WEST SUSSEX COUNTY COUNCIL CONSULTATION

TO:	Arun District Council FAO: Michael Eastham
FROM:	WSCC - Highway Authority
DATE:	4 March 2022
LOCATION:	Phase 5 Hampton Park Toddington Lane Littlehampton BN17 7PL
SUBJECT:	LU/206/21 Approval of reserved matters following outline consent LU/47/11/ for the development of 260 No. dwellings and the construction of the Central Spine Road running through Hampton Park. This site is in CIL zone SP2 and is not CIL Liable as strategic site.
DATE OF SITE VISIT:	n/a
RECOMMENDATION:	More Information Required
S106 CONTRIBUTION TOTAL:	SEE S106 AGREEMENT FOR OUTLINE PROPOSAL

This is the third WSCC Highways (CHA) response to the above planning application for approval of reserved matters following outline consent LU/47/11/ for the development of 260 No. dwellings and the construction of the Central Spine Road running through Hampton Park.

PROPOSED SWALE TYPICAL CROSS SECTIONS

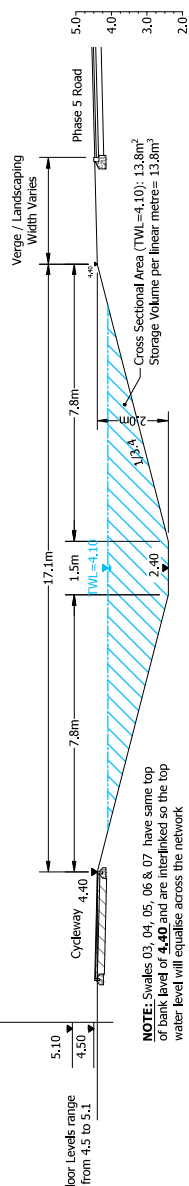
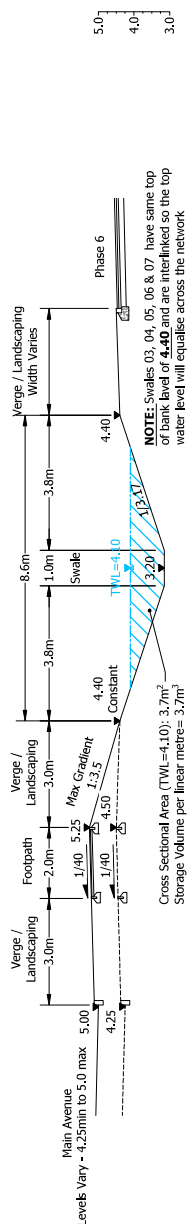
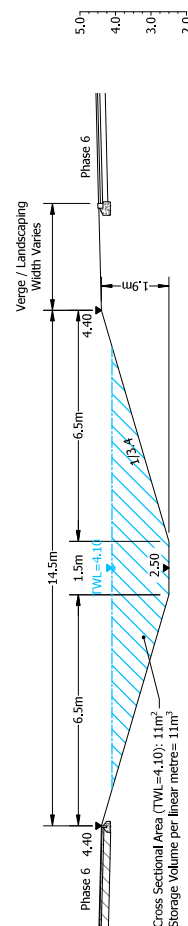
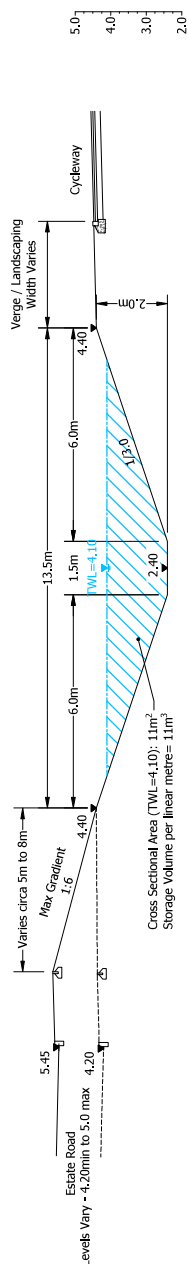
Structures - In its previous response, the CHA also mentioned the presence of structures within the development. The consultant has said for details, please refer to Mayer Brown "Swales 03 & 04 Construction Details and Setting Out" drawing reference MB/F/03.

The applicant has noted the previous WSCC CHA comments about the minimum 1.2m headroom for culverts defined in CD 529. They have stated that the shared use paths and culverts in the wetland will not be offered for adoption. They also state that the footpath levels are such that the minimum headroom requirement cannot be achieved for the culverts. They also say that these are also less than 12m in length, and therefore the designer considers that the 1.2m minimum headroom should not be required for these structures. They reference Mayer Brown "Proposed Levels and Drainage" drawing ref. PHLITTLE-CWA.10/20. For more details.

Comments noted about these now being footbridges. Further comments by the CHA might be forthcoming following consultation with WSCC Structures Dept.

From the CHA's perspective (whether the structures are to be offered for adoption or left private), WSCC would still require oversight of the design for due diligence purposes. Post-planning, the applicant would need to provide details of each of the proposed structures so that WSCC can have an overview and store records of the private structures accordingly. The design submission will need to provide a sound technical reasoning for any lower than desirable headroom proposed.
